Loft alterations including a rear roof extension and a larger replacement dormer on the east elevation.

The Gables South Strand East Preston

The Planning Committee of East Preston Parish Council considered this Application at its meeting on Monday, 11th February.

PROPOSED SIDE ELEVATION 1:100

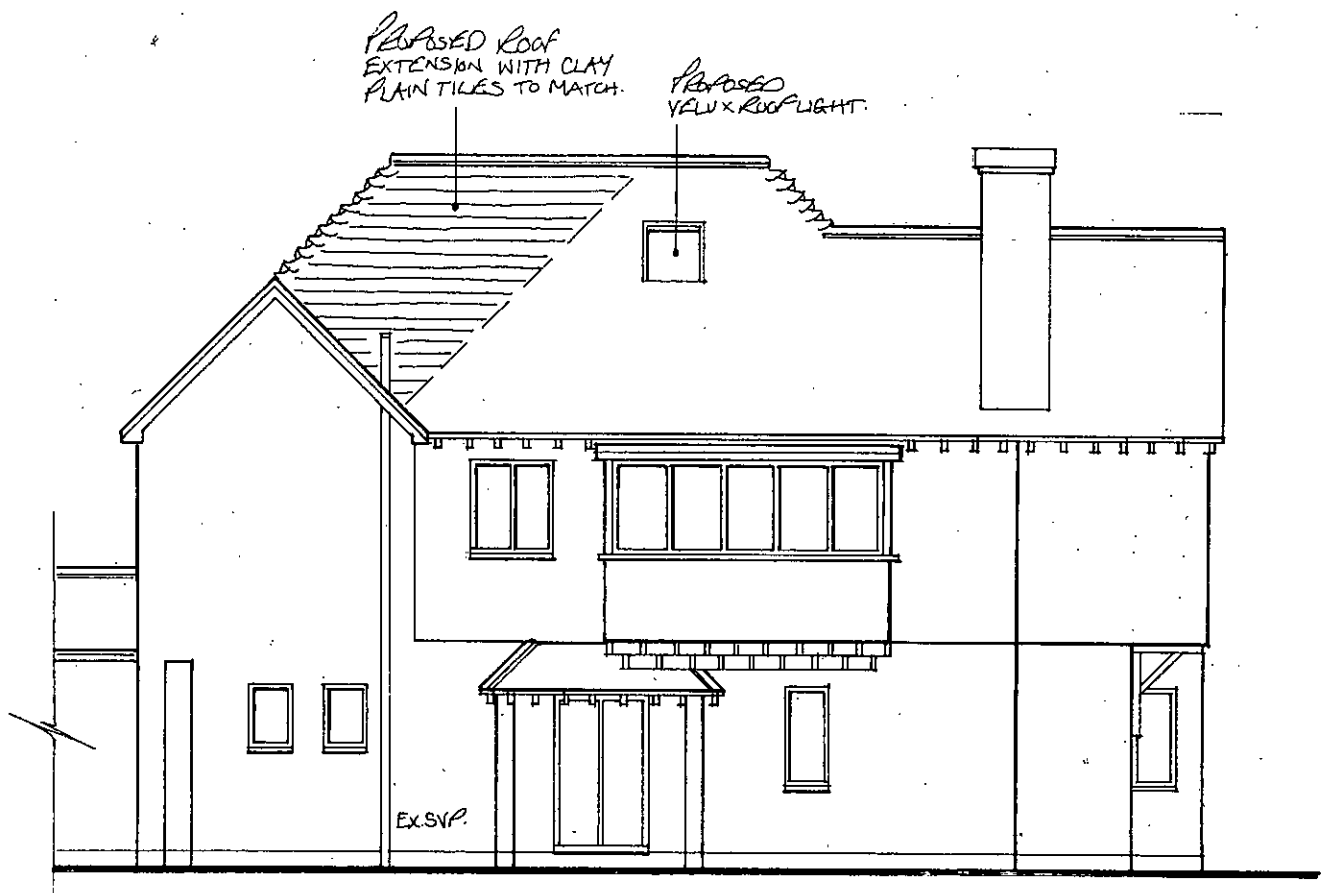
The property is in a prominent location within the Angmering-on-Sea Estate. The committee was concerned that whilst some of the proposal possibly tidies up on the existing property, there is a risk that the roof extension and triple-window dormer will result in a top-heavy building. This was not easy to judge from the drawings submitted.
